From: Sue Howell
Sent: 25 May 2017 16:00
To: Planning.Responses
Cc: Anita Gardner
Subject: RE: Planning Consultation on: LU/94/17/OUT

Comment from Greenspace

APPLICATION LU/94/17/OUT

Description of Works: Outline application with all matters reserved for residential re-development comprising of 10 No. dwellings & associated works (resubmission following LU/327/16/OUT).

Conceptual Site Layout

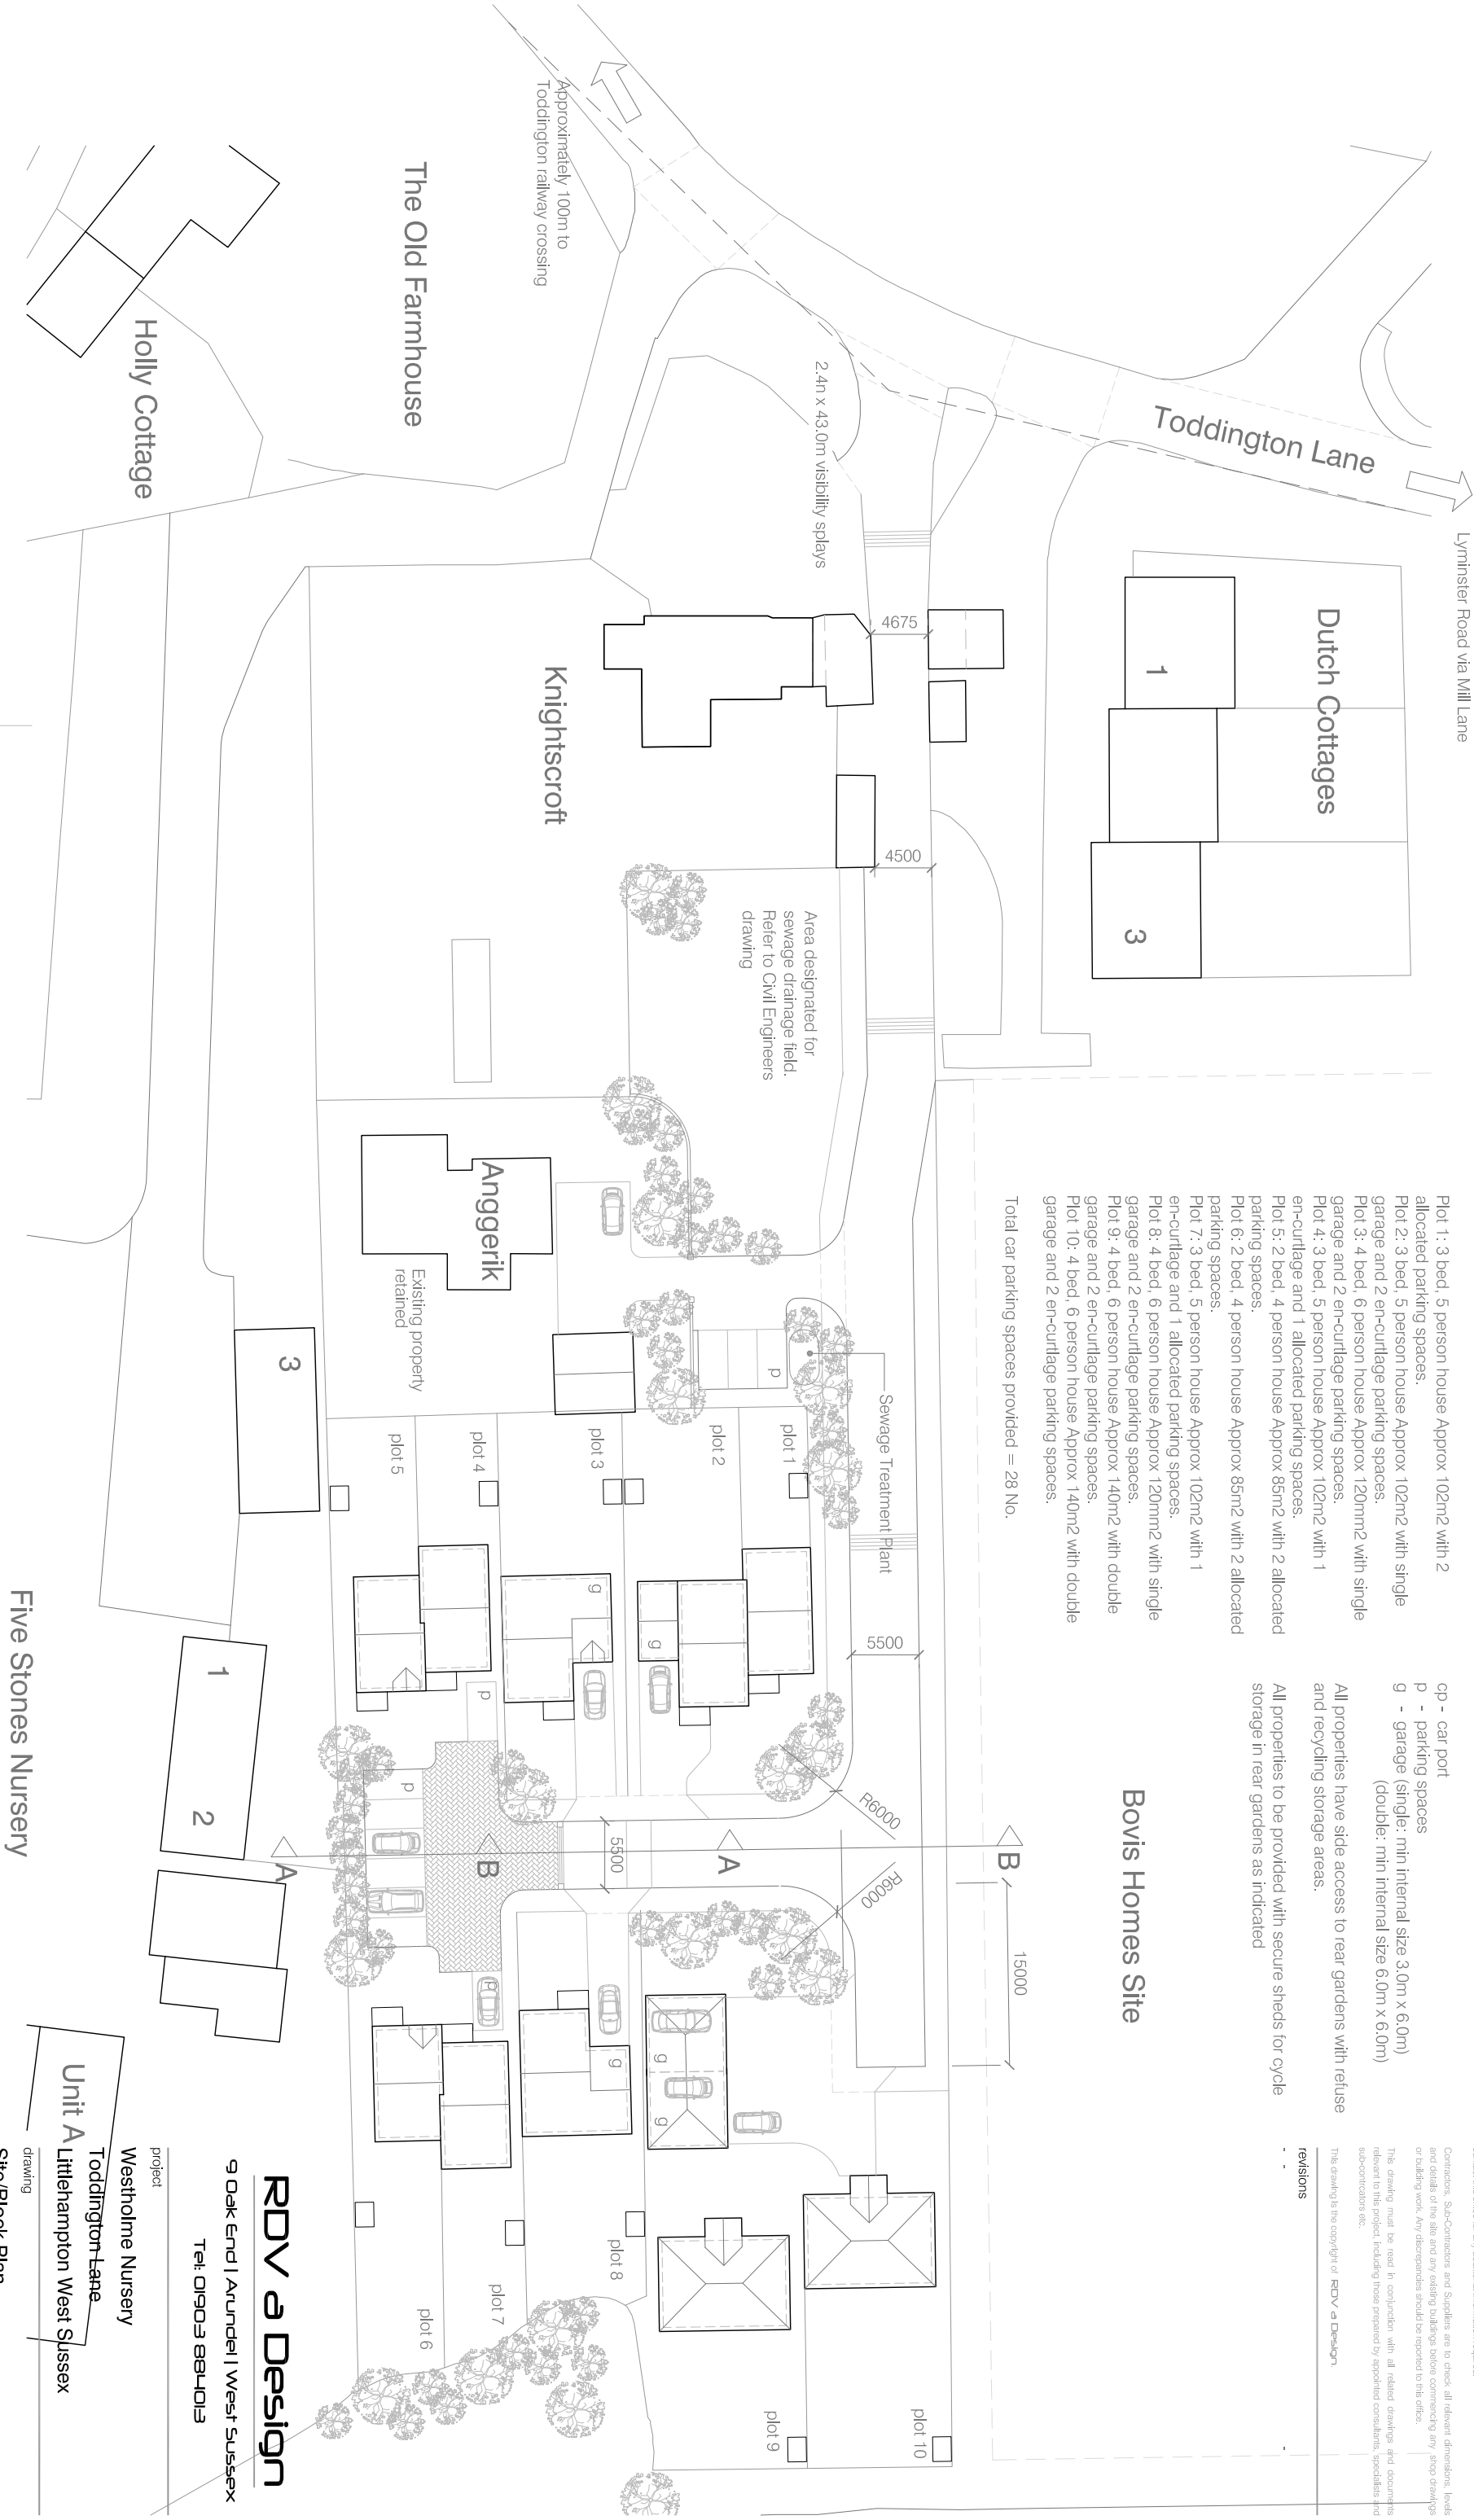
Developments of 10-200 dwellings or more are expected to provide open space on site. The Council's SPG guidelines which apply to developments of houses and are based broadly upon the National Playing Fields Association's (NPFA) "Six Acre Standard". Under superseded Fields in Trust guidelines (FIT) this requires that 3.2 hectares of open space are provided for every 1,000 people ie 32 square metres of open space per person. We would require confirmation of the areas of public open space being proposed with this development.

Due to the number of residence exceeding 7no this would trigger the requirement for public open space on site, but not on-site play provision. The requirements for this would equate to 768m2 of open space on this development, which is not being catered for within the plans submitted. In this instance we would therefore request a commuted sum to mitigate against this. This we would request at £1000.00 per dwelling therefore £10,000 for this development.
